The following is a narrative code review for your proposed division on the large space on your plan sketch into 5 studio spaces.

RE: 299 Presumpscot Street  
Portland Maine, 04103

A1-1

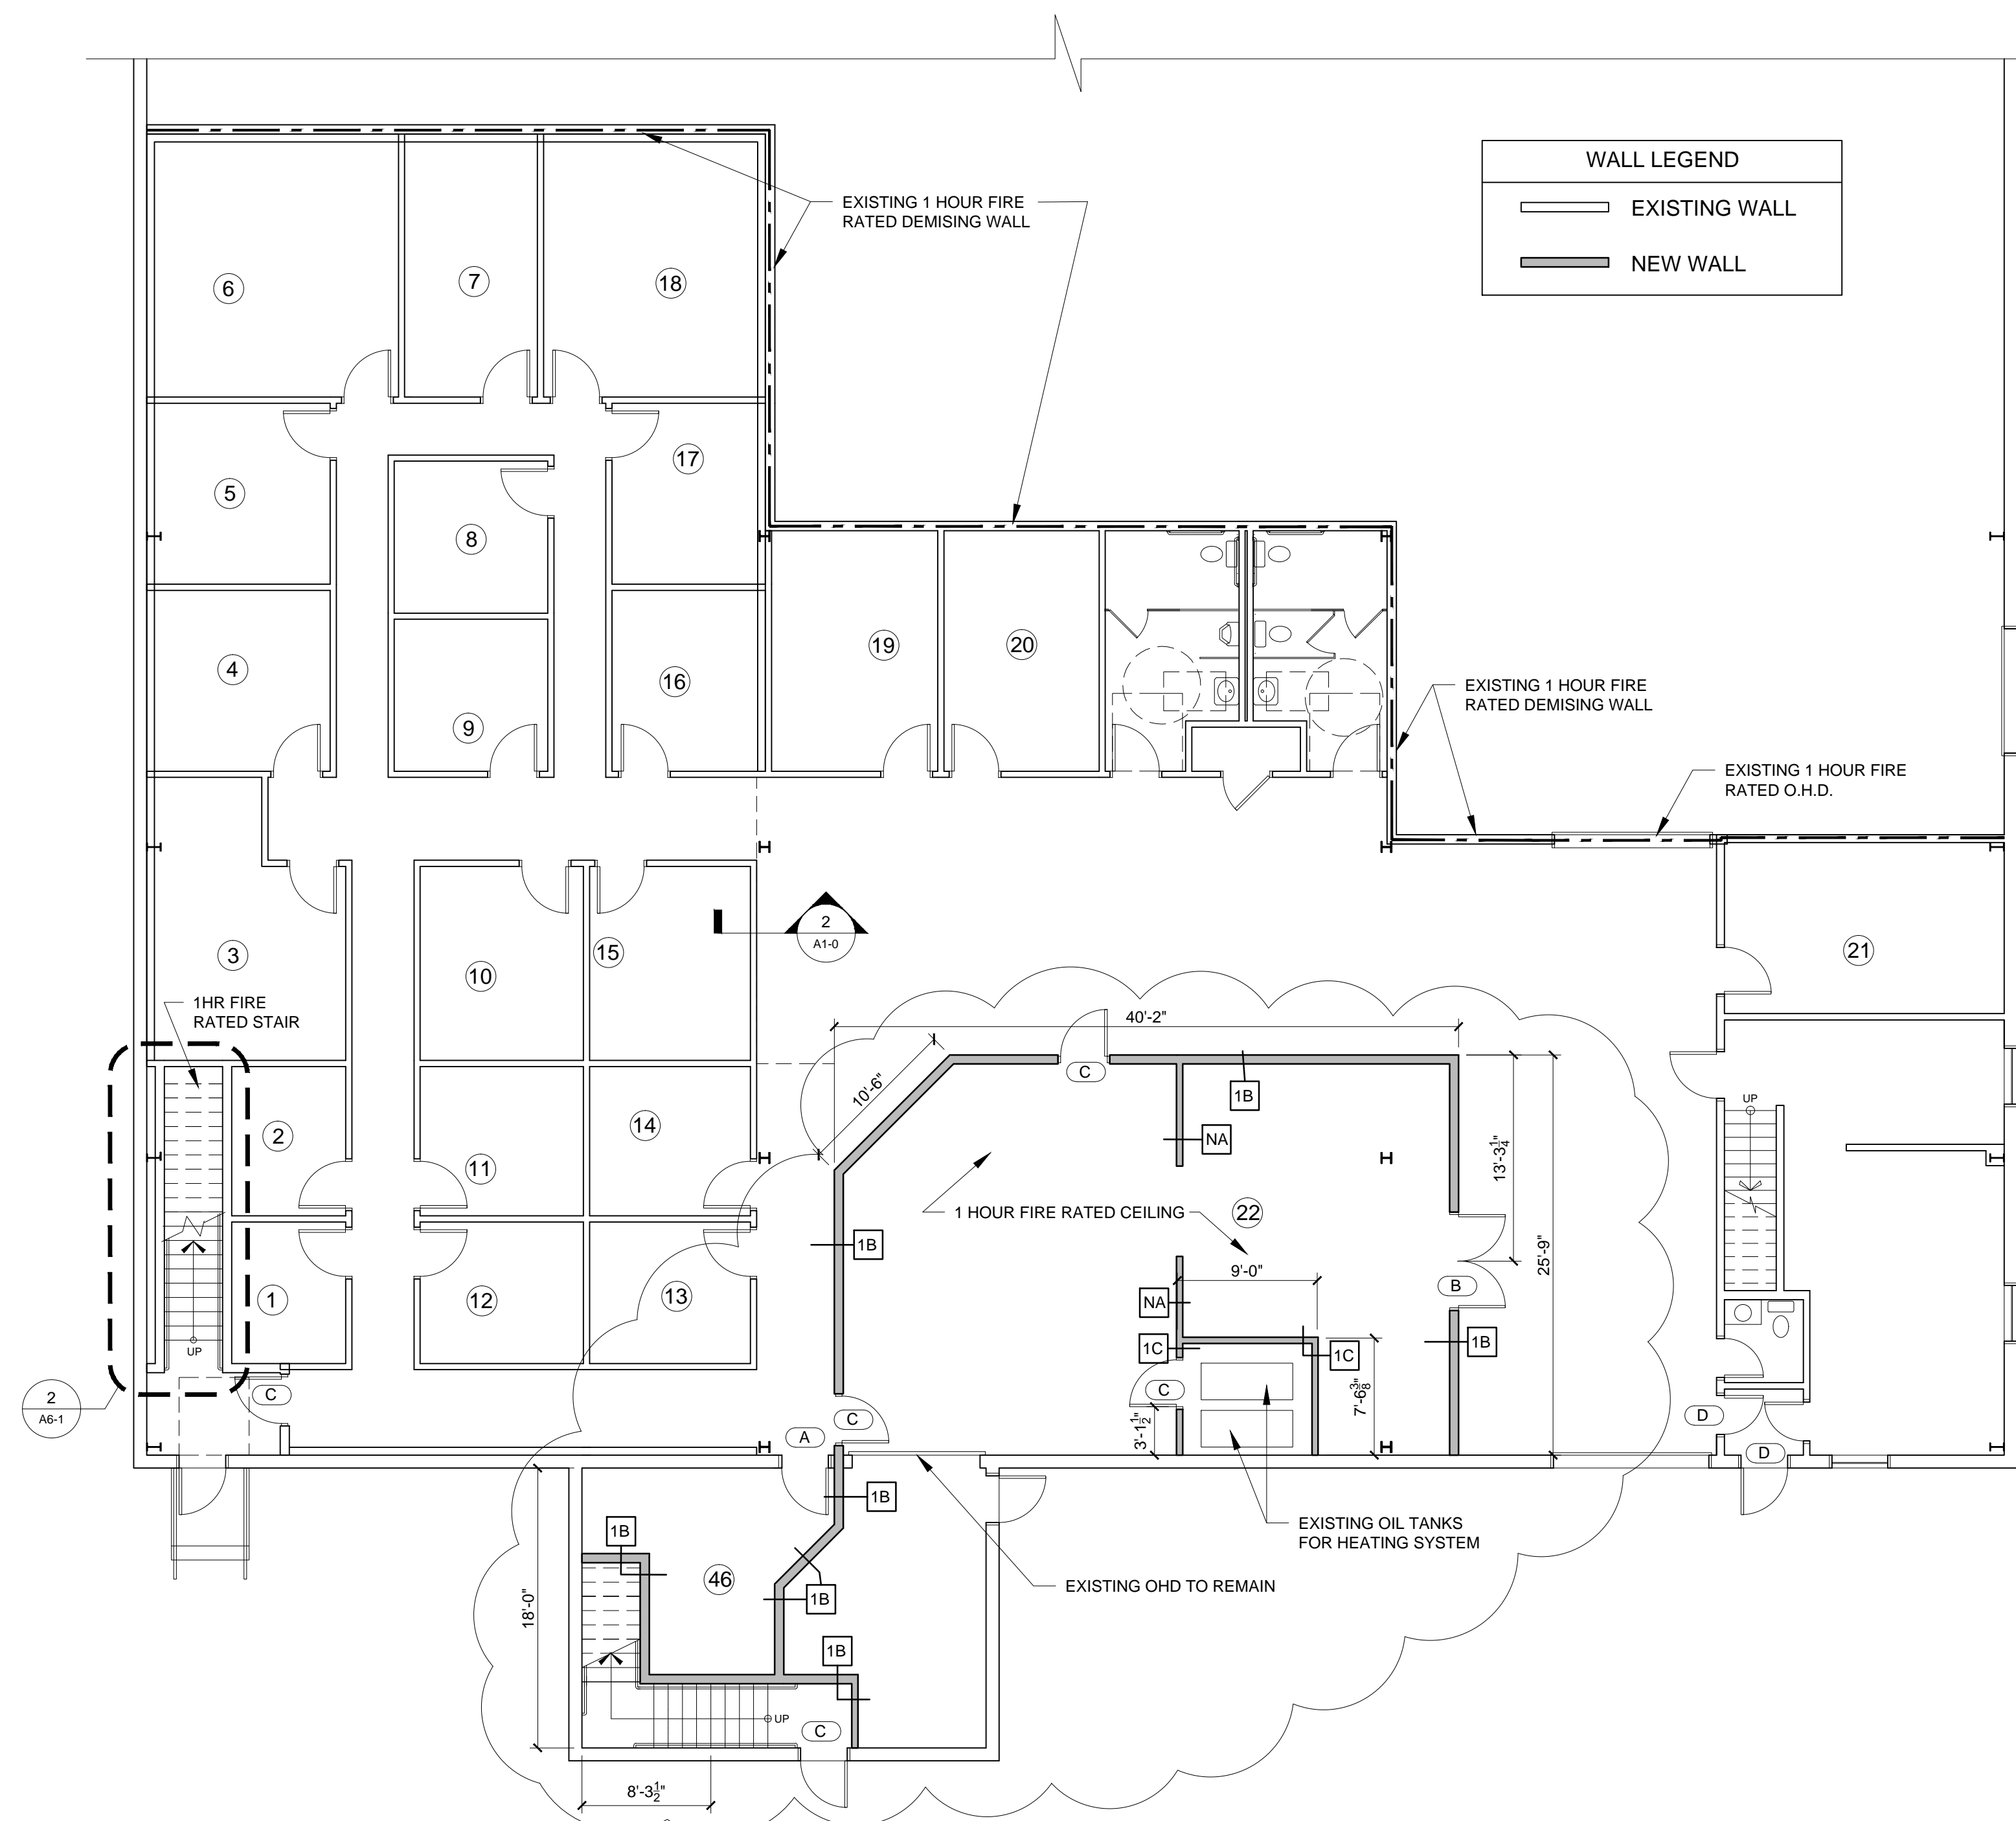
- The uses of the spaces is to match the other studio spaces in the building
- The doors to the studio spaces shall be type 'A' doors as indicated on our original plans
- The interior non-load bearing walls are to be type 'NA' as indicated on our original plans
